WEST SUSSEX COUNTY COUNCIL
COUNTY HIGHWAYS CONSULTATION RESPONSE

SUBJECT: LU/426/17/DOC - Approval of details reserved by condition imposed under LU/234/16/RES relating to condition 7 for details of acoustic barrier.

LOCATION: Fitzalan Link Road, East Street, Littlehampton, West Sussex.

This is the third WSCC highways and transport response to the planning application. It follows review of additional information as shown on Drawings A088461 FL1 & 2[K]. DWG produced by WYG Environmental Planning Consultants on behalf of Persimmon Homes (Drawings dated 6th March 2018).

FL.1

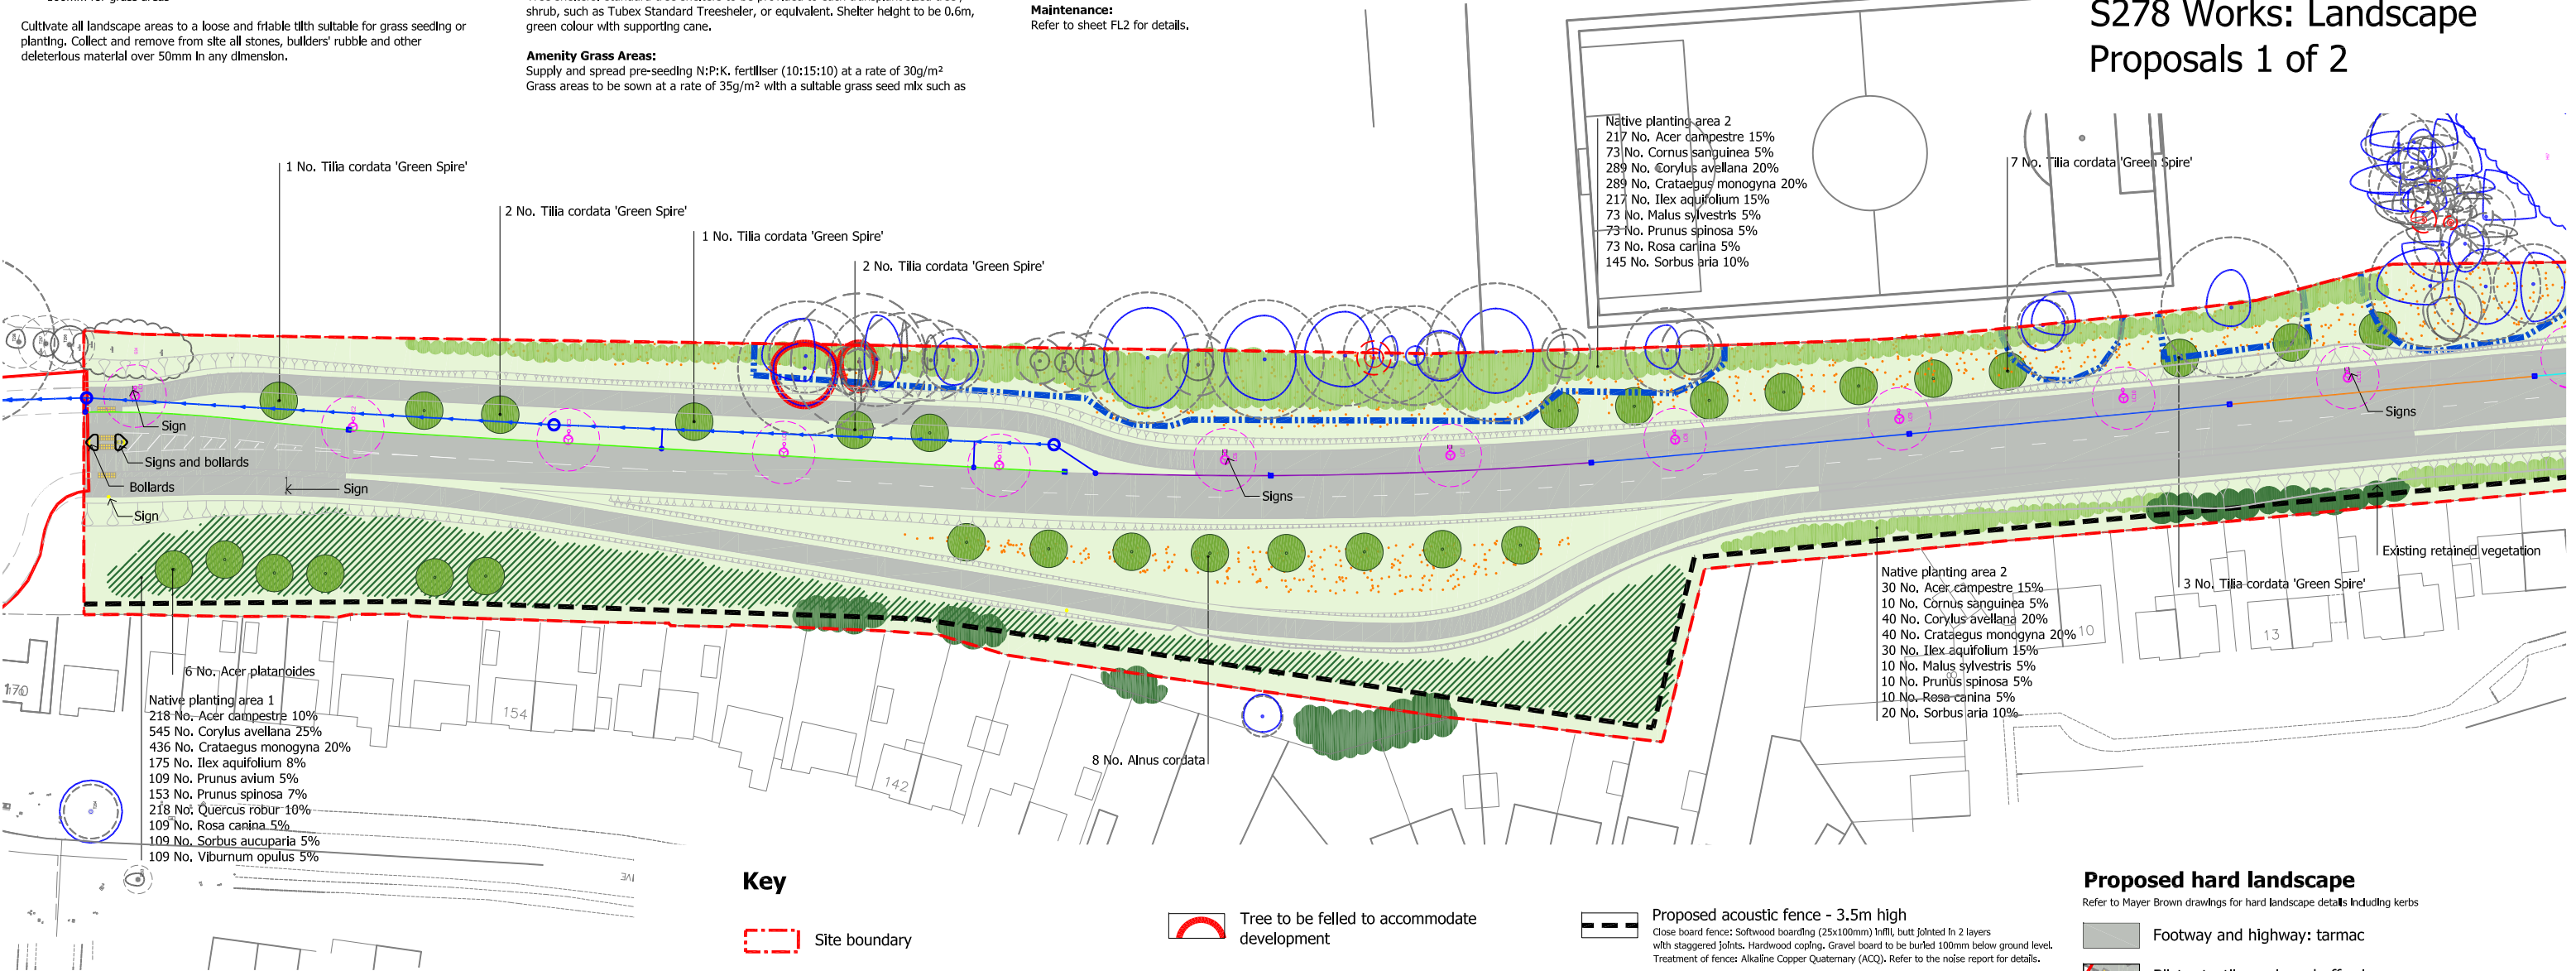
1. Neither the drawings supplied, nor the detailed design drawings adequately specify the topsoil requirements for planted areas. *Applicant to provide details.* Dwg no. FL.1 now provides this information. Will be reviewed further at S38/278/detailed design stage.

2. The land between the site boundary and the acoustic barrier will need to be levelled, and surfaced with a weed proof membrane and type 1 gravel surface. Amenity grass is not suitable here. *Applicant to confirm that this will be provided.* Plan has been amended to show this.

8. Vegetation to rear of 124 Highdown Drive (green area): Partial removal required for construction of acoustic barrier and future access. *The design needs to be amended to show this planting being removed.* See amended plan FL.1 Revision K. Applicant has partially removed the existing vegetation. Will be reviewed further at S38/278/detailed design stage.

Landscape Proposals 2 of 2

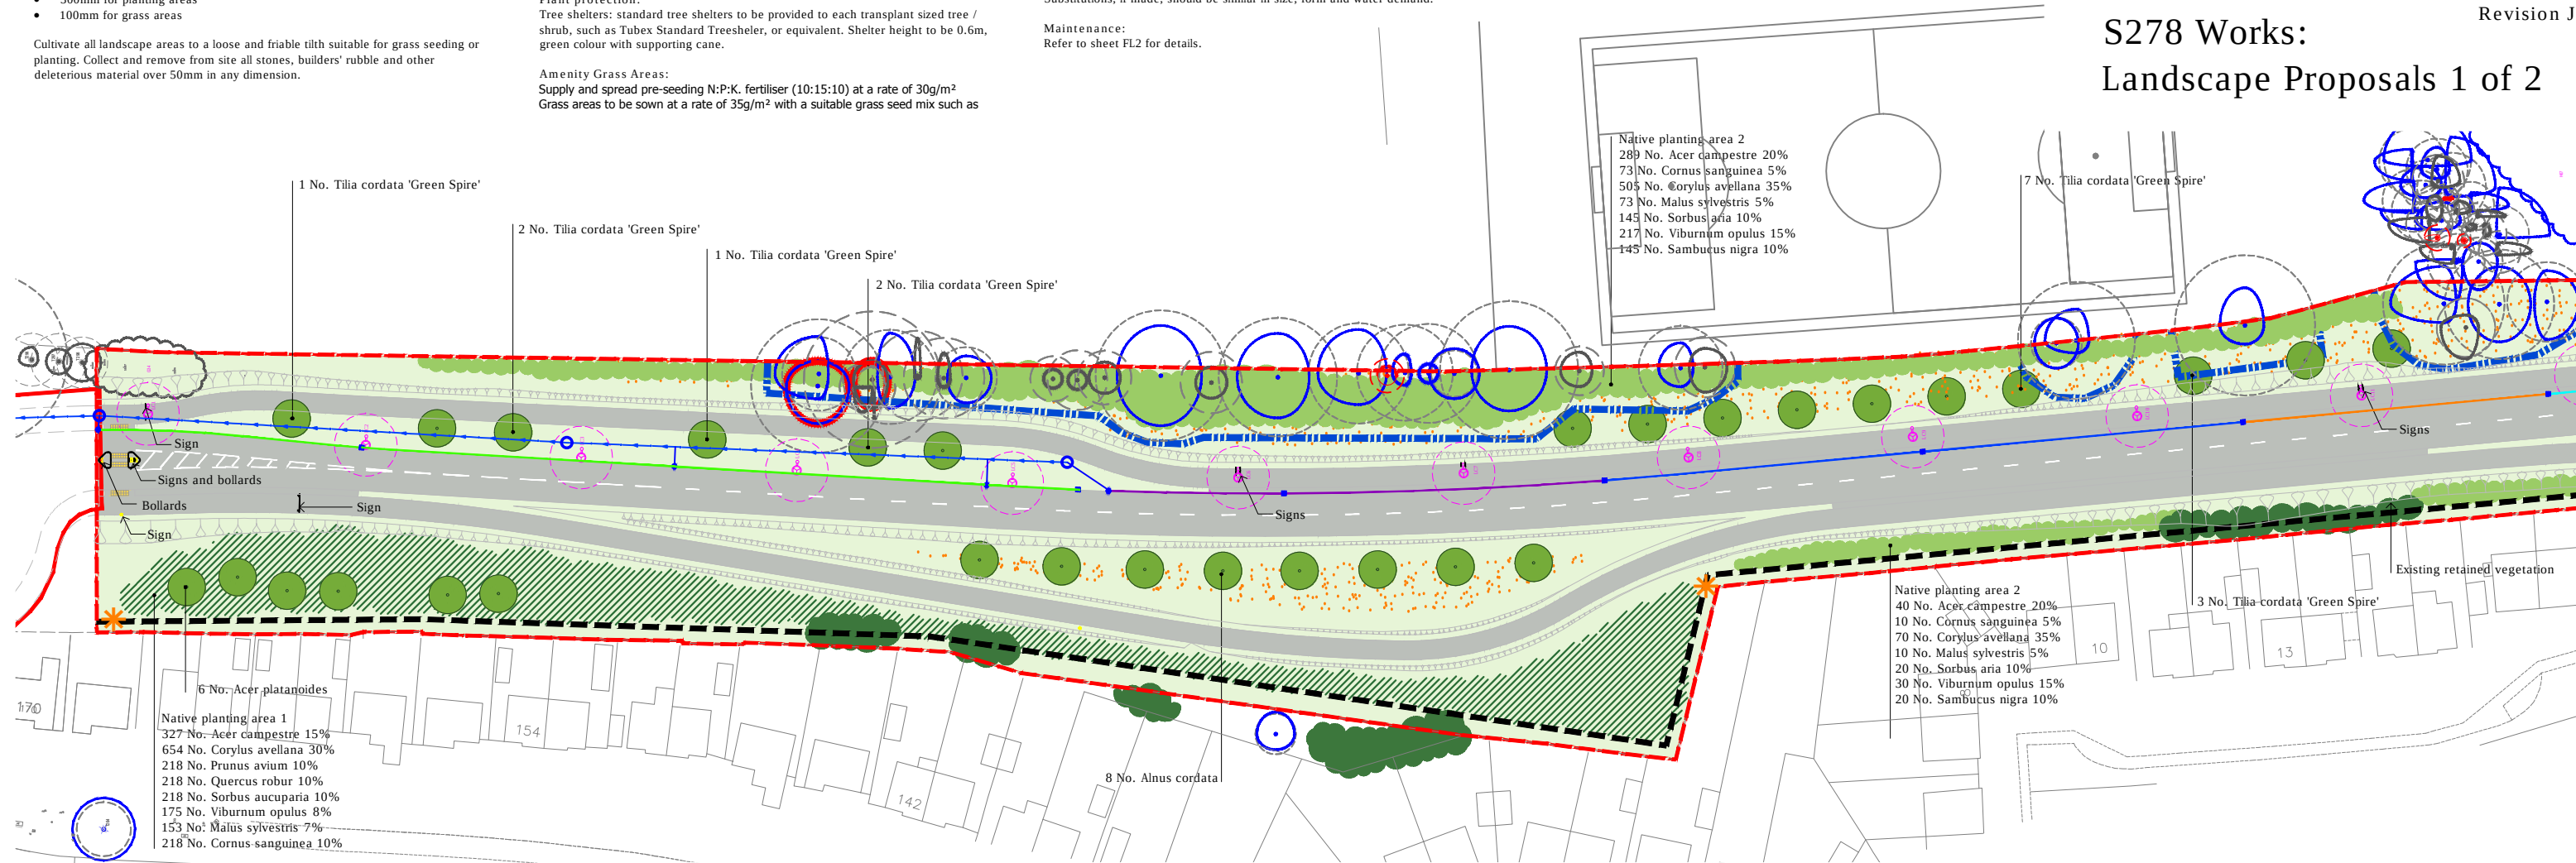
10. Vegetation to rear of 18/19 Amberley Close (blue area): Removal required for construction of acoustic barrier and future access. *The design needs to be amended to show this planting being removed.* See amended plan FL.2 Revision K. Will be reviewed further at S38/278/detailed design stage.
